SUBDIVISION PLAN OF THE BAY HOUSE, PHASE II
 NEWBURY/HANCOCK STREET
 PORTLAND, MAINE
 FOR 113 NEWBURY STREET, LLC
 35 FAY STREET, SUITE 107B
 BOSTON, MA 02118-4320

SHEET 4 OF 13

**SHEET 4 OF 14**

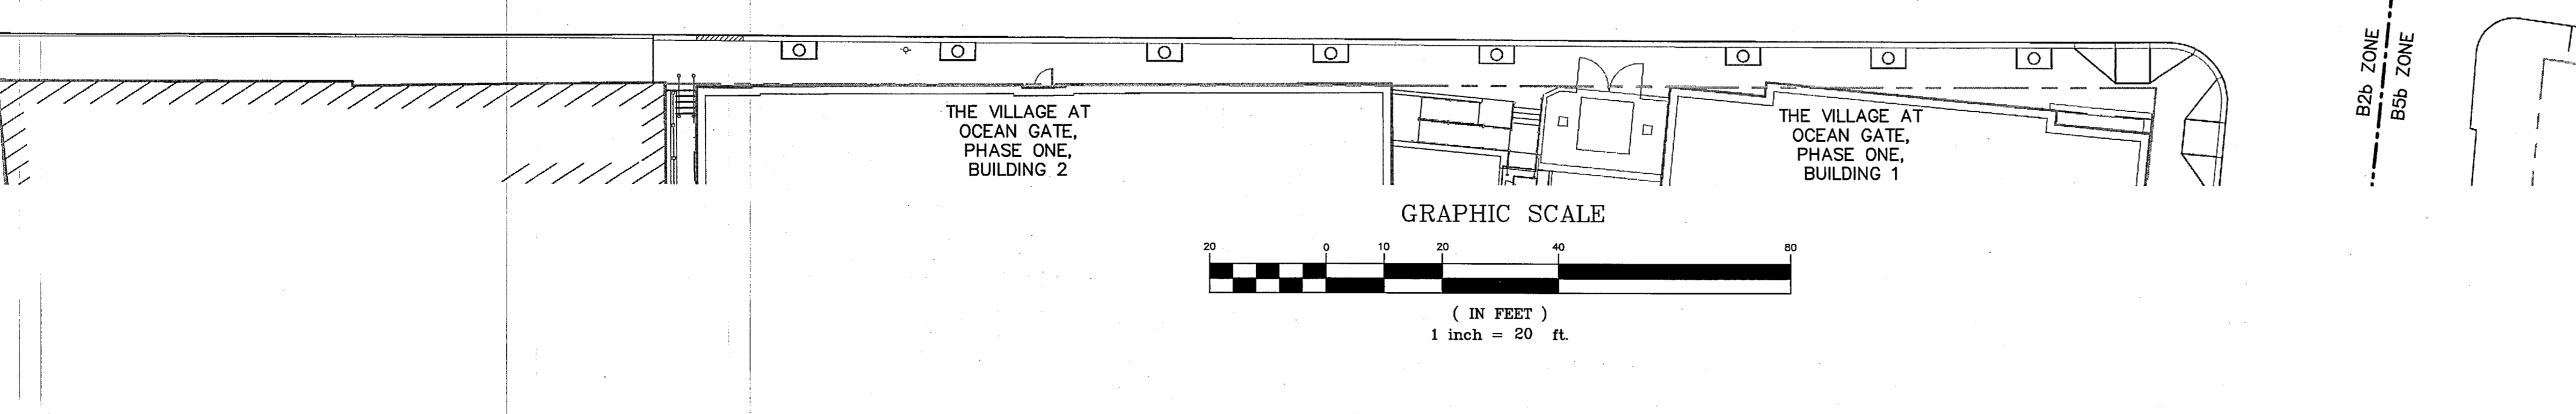
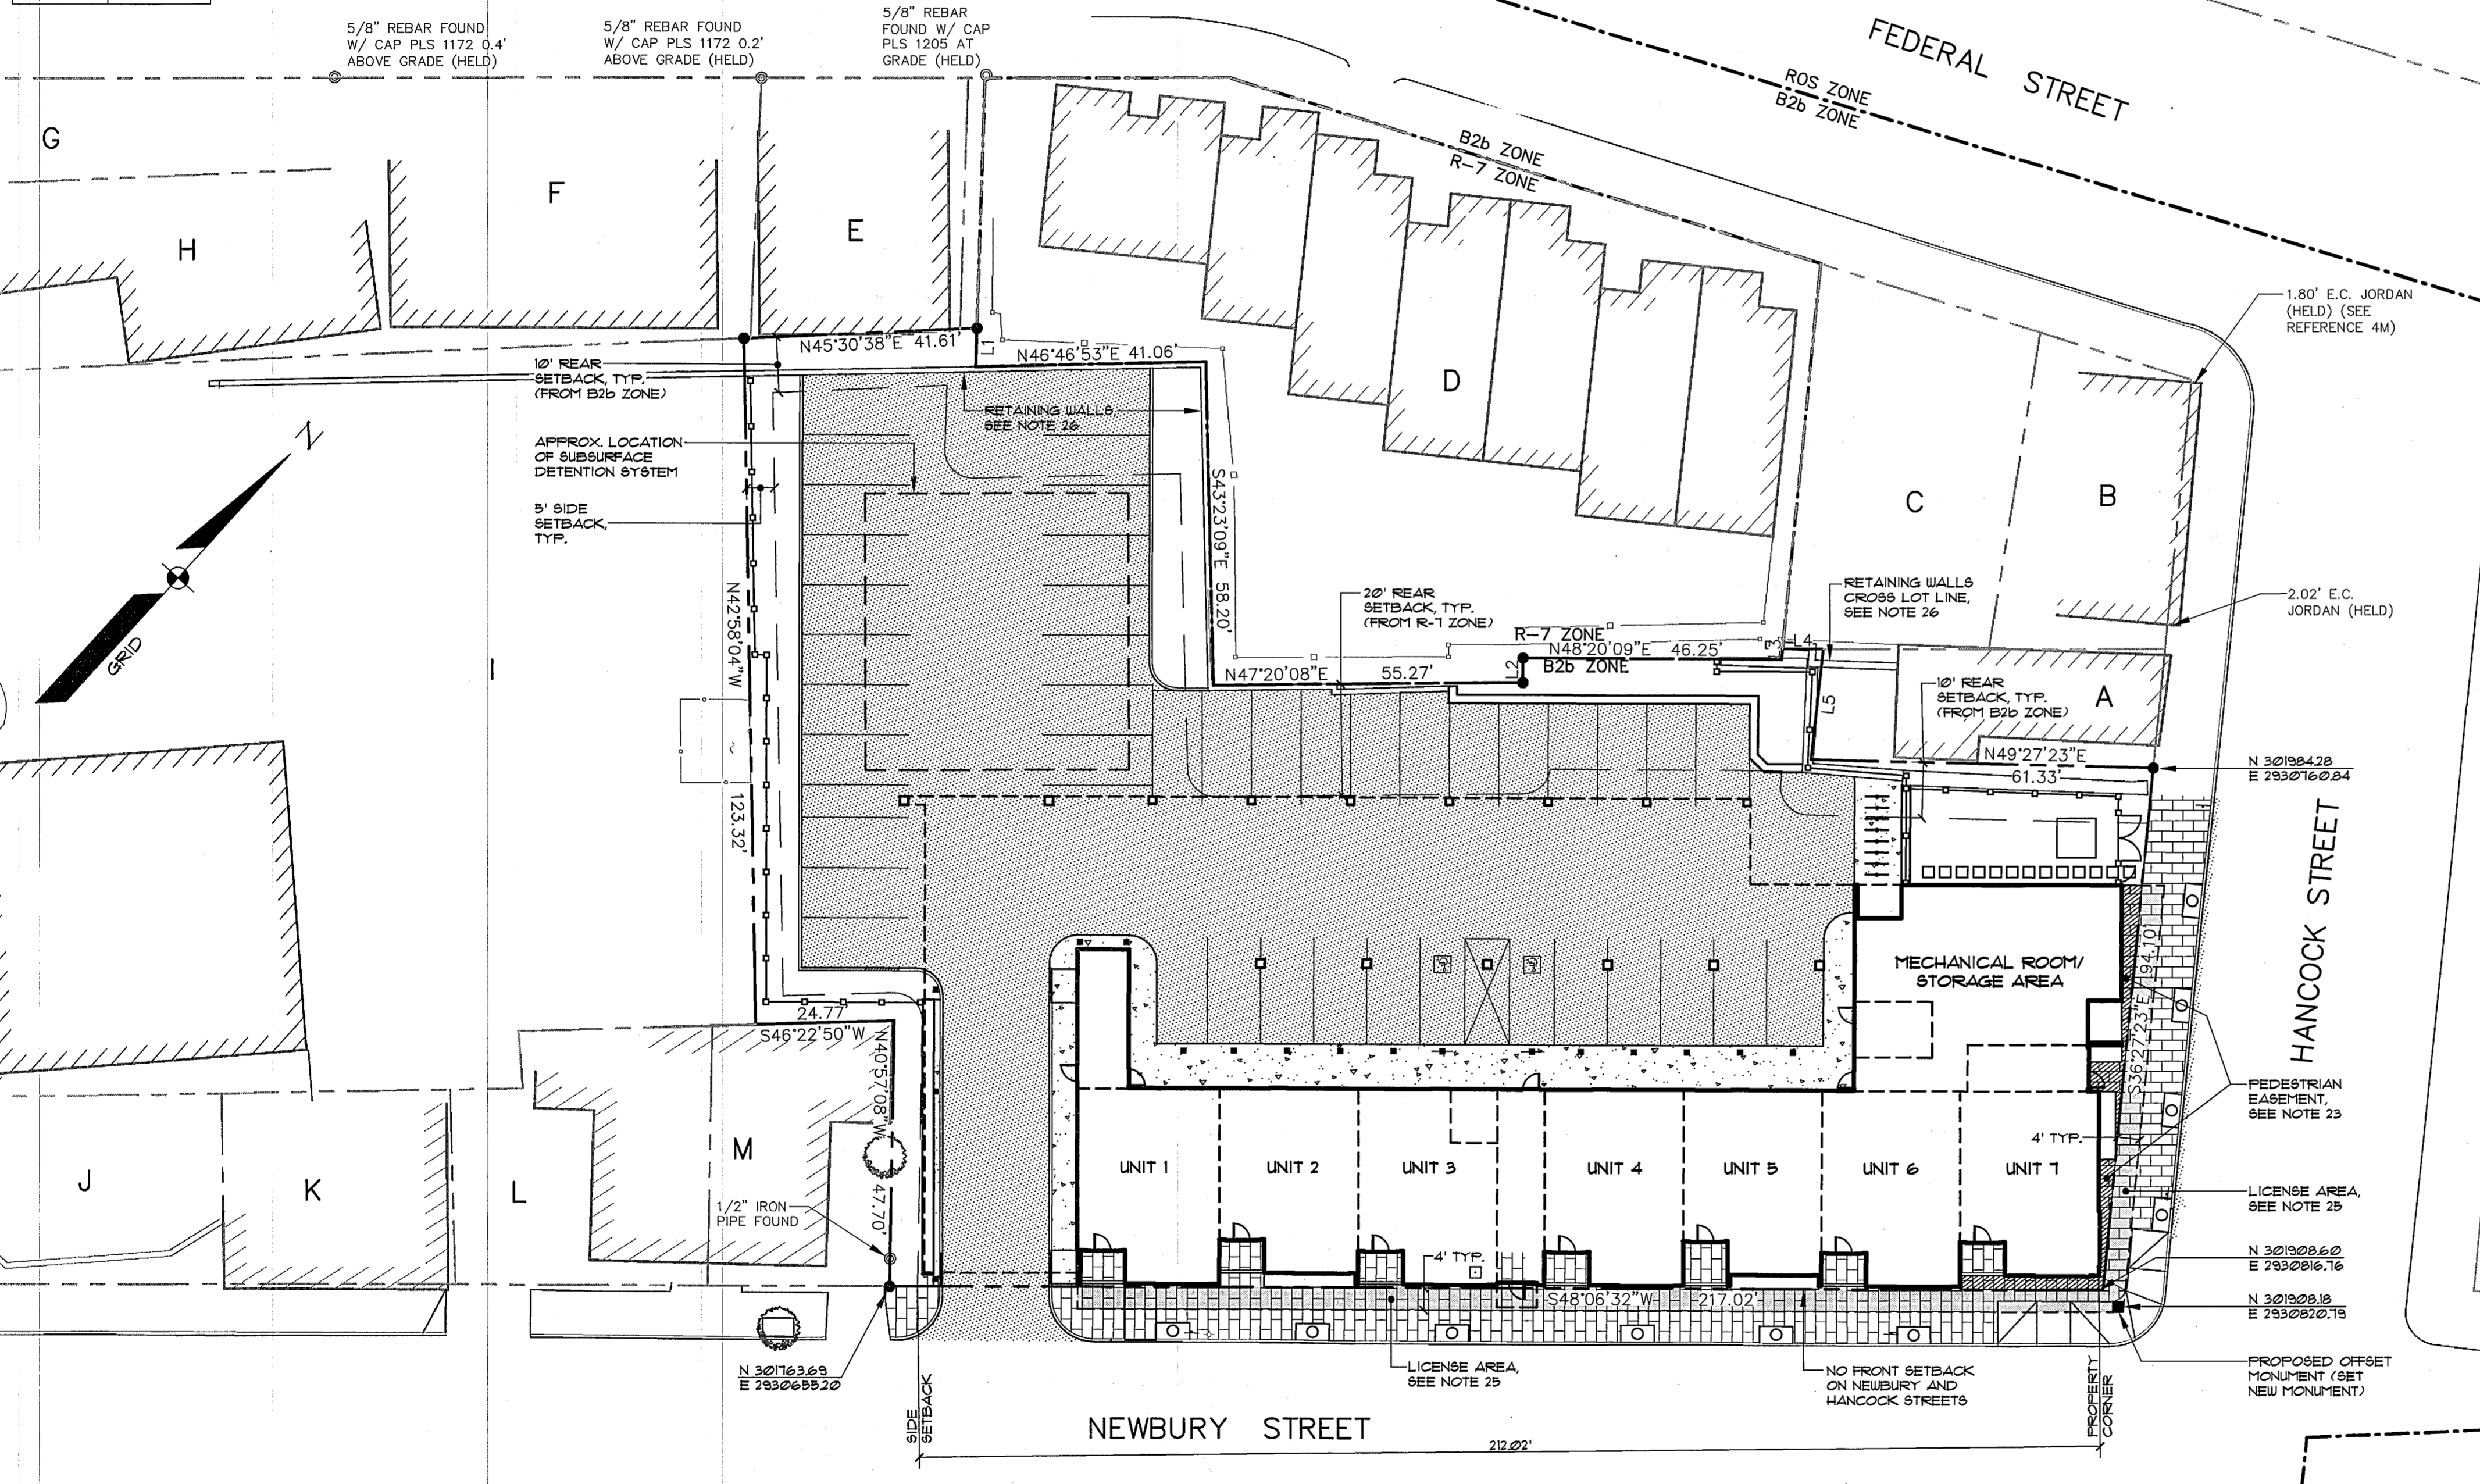
- NEED TO SHOW PROPER CORNERS TO SET
 - WILL THERE BE LICENSES BY THE CITY FOR FOUNDATION FOOTINGS IN STREET ROWS?
 WBC 9/05/13
